THE SHOP'S AT MERIDIAN RANCH

FILING NO. 1A, LOT 2

PHOTOMETRIC PLAN

EL PASO COUNTY, COLORADO.
FALCON, COLORADO

PHOTOMETRIC PLAN

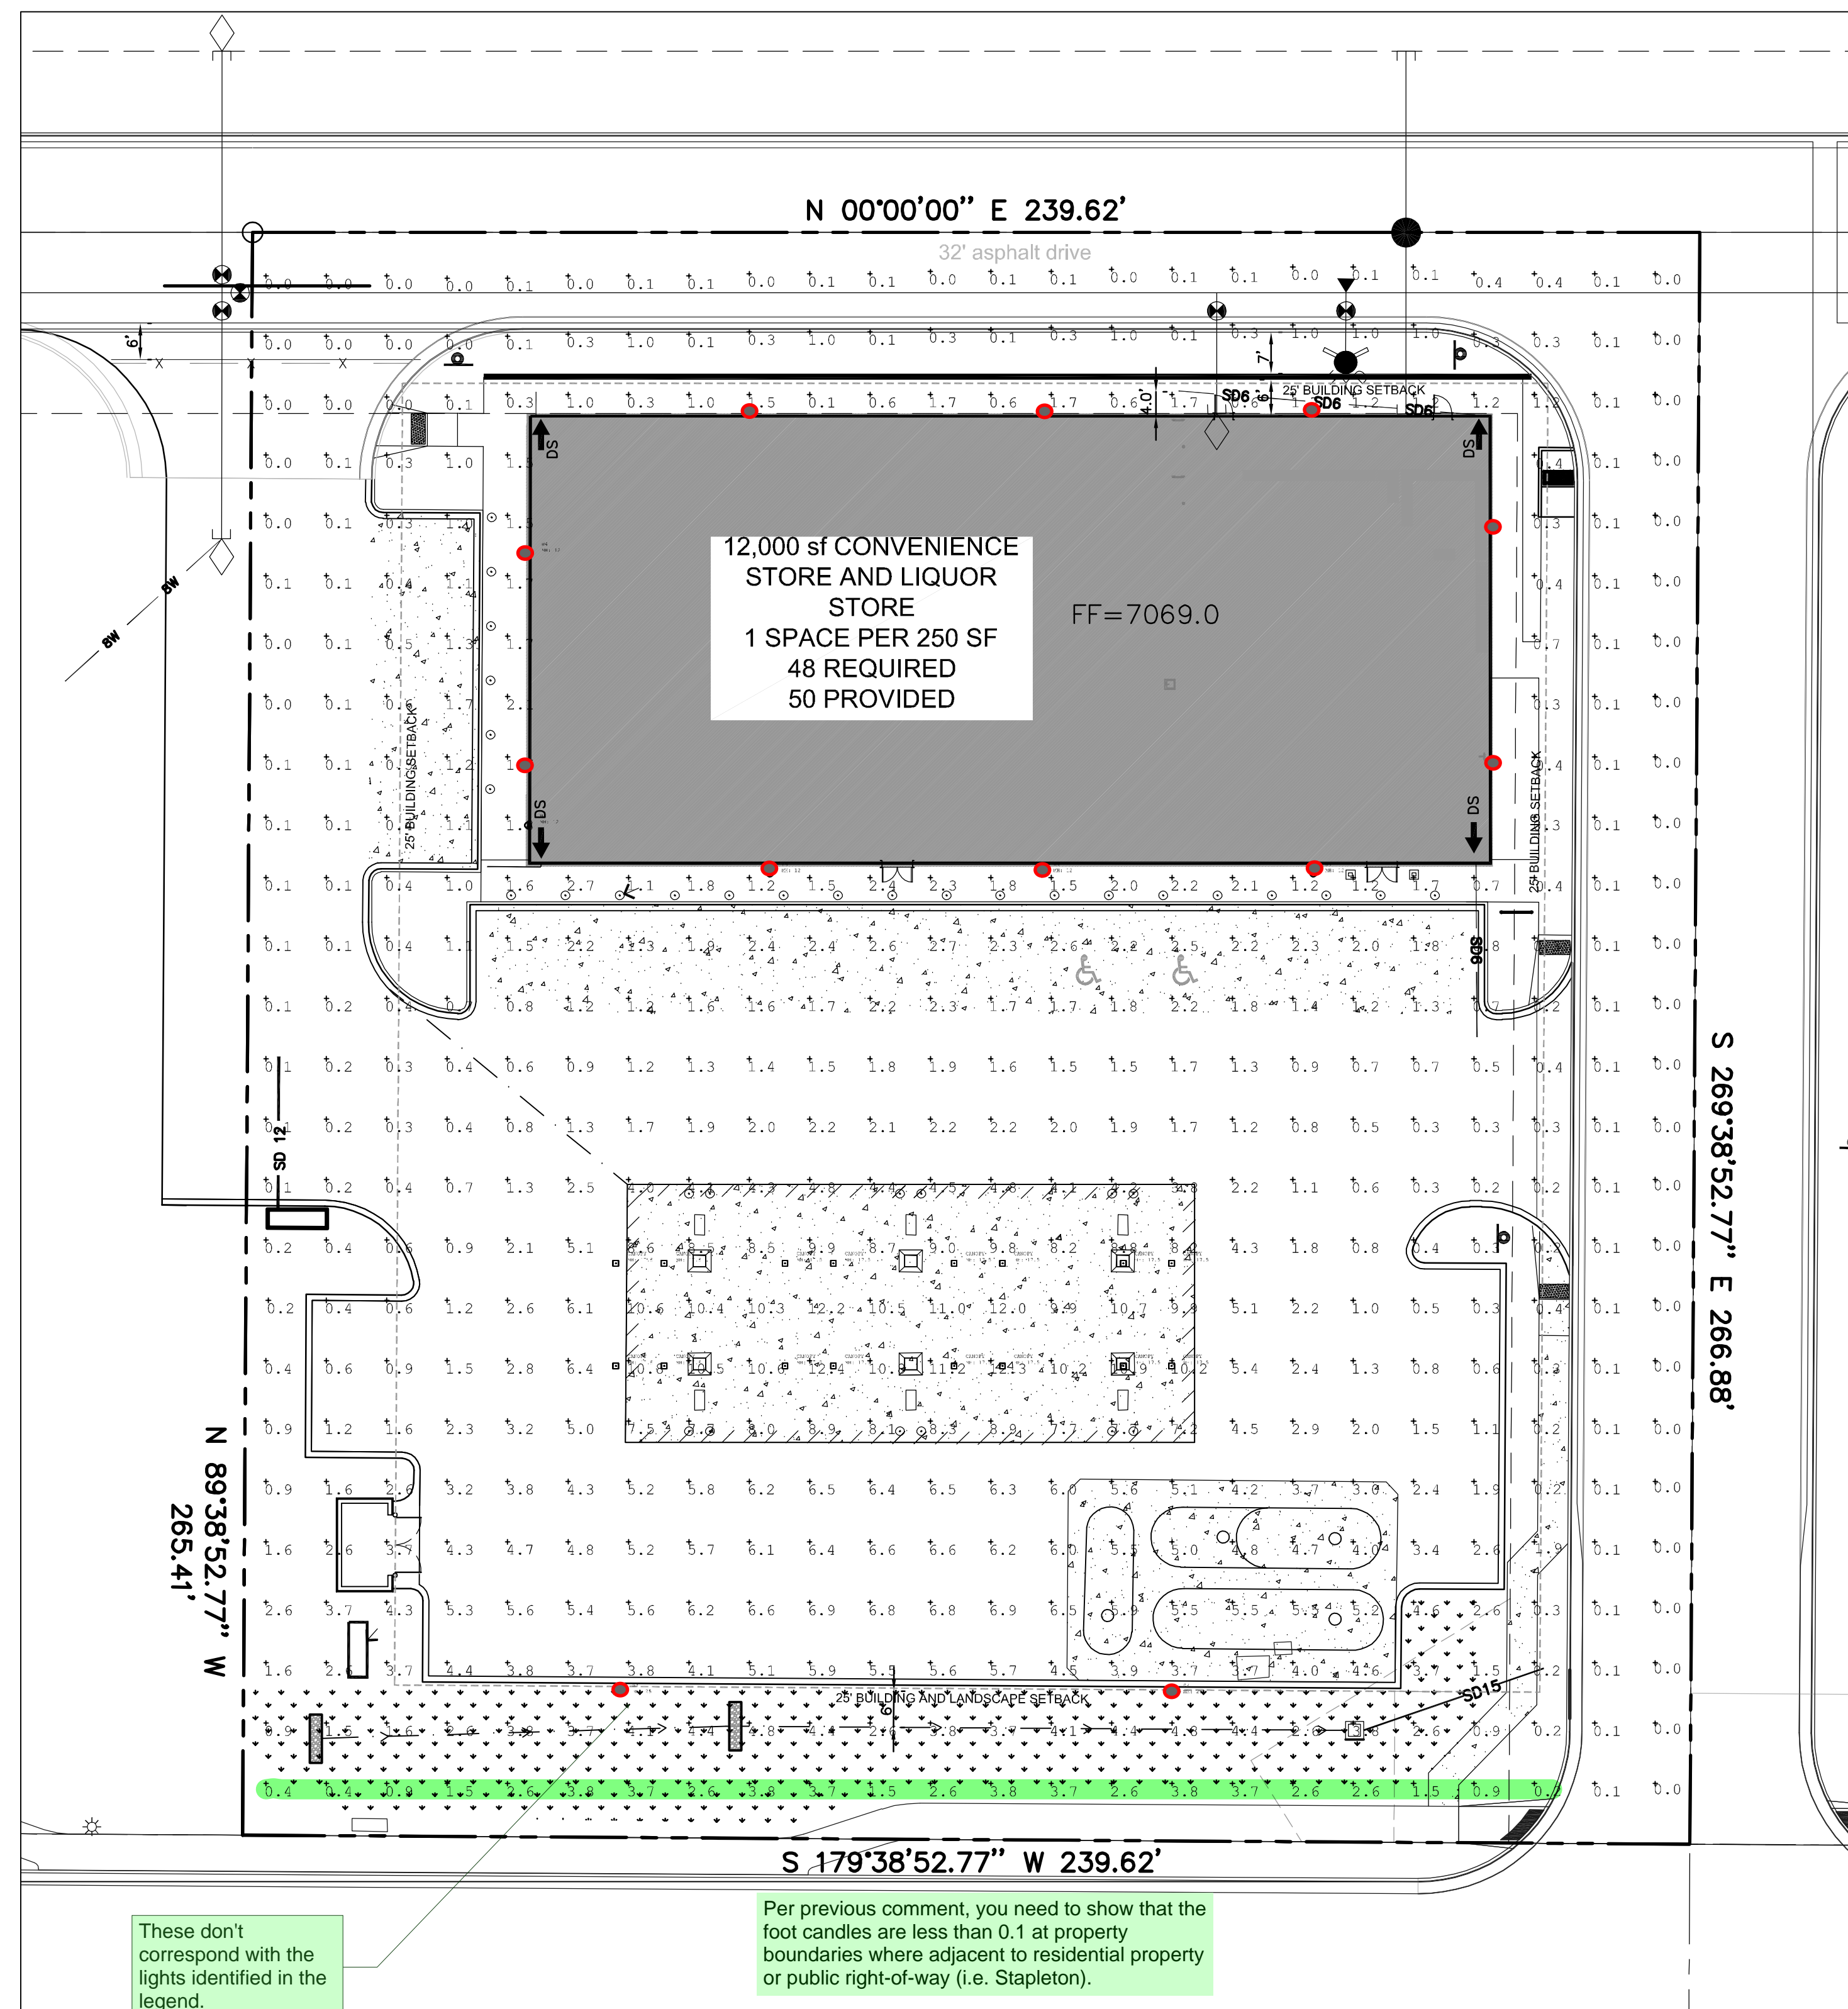
Fixture locations do not appear to be depicted on the plan set, and if they are, they are very difficult to locate based on the symbols in the luminaire schedule. Please update this plan for clarity.

This lighting plan doesn't provide photometrics for the entire site - it only provides for the parking lot. You need to show that the foot candles are less than 0.1 at property boundaries where adjacent to residential property or public right-of-way (i.e. Stapleton).
